From: [Wade Metz](#)
To: [Jeremiah Cromie](#)
Subject: Clear View (SE-21-0017)
Date: Sunday, September 12, 2021 11:15:26 AM

My name is Wade Metz and I live at 621 Whisper Creek Drive in Cle Elum. There is a 4 lot plat being proposed near our home on Whisper Creek. The developer is Clear View, LLC. I have read and reviewed the SEPA application as well as looked at the plat layout.

**CLEAR VIEW ACRES SHORT PLAT
KITITAS COUNTY SHORT PLAT NO. 06-XX
PTN. OF THE WEST 1/2 OF SEC. 1, T.19N., R.14E., W.M.
KITITAS COUNTY, WASHINGTON**

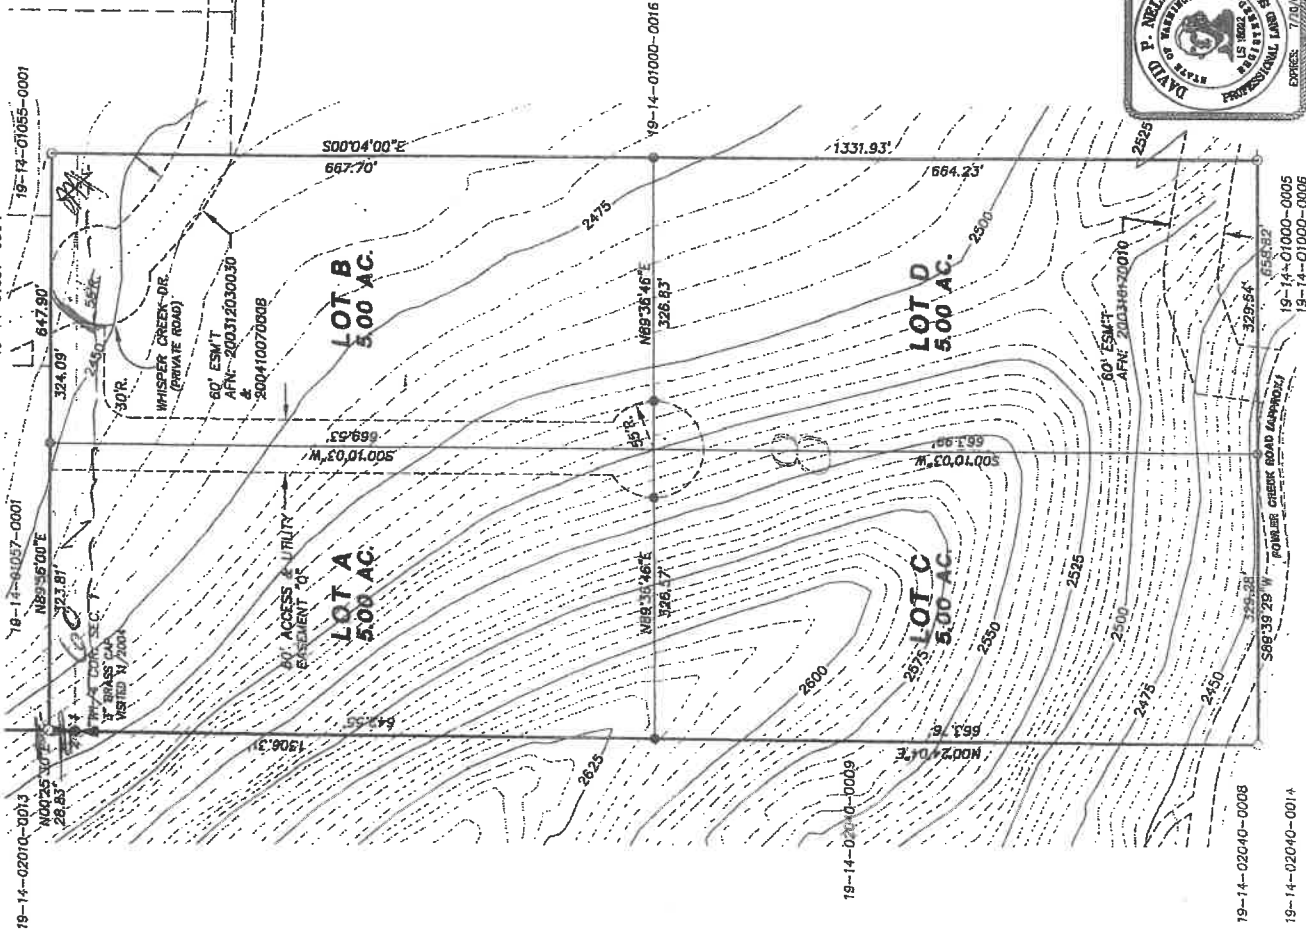
1. Road. We like the secondary road access to Pasco road for emergency use only and not for primary access or through traffic. If there were ever a fire or emergency that didn't allow us to leave through the normal gate, it would be helpful to have a 2nd means of egress from our plat. As our plat is a gated community on a private road, we'd assume that the access connection to Pasco would also be gated. Our preference would be a manual gate, so as to discourage daily travel through our neighborhood. Truly an emergency gate.
2. Road standards. We hope that you require them to match our community ROW width and paved road standard. Not a gravel road. We moved into our community specifically to get away from communities that do not have a gate and are gravel roads.
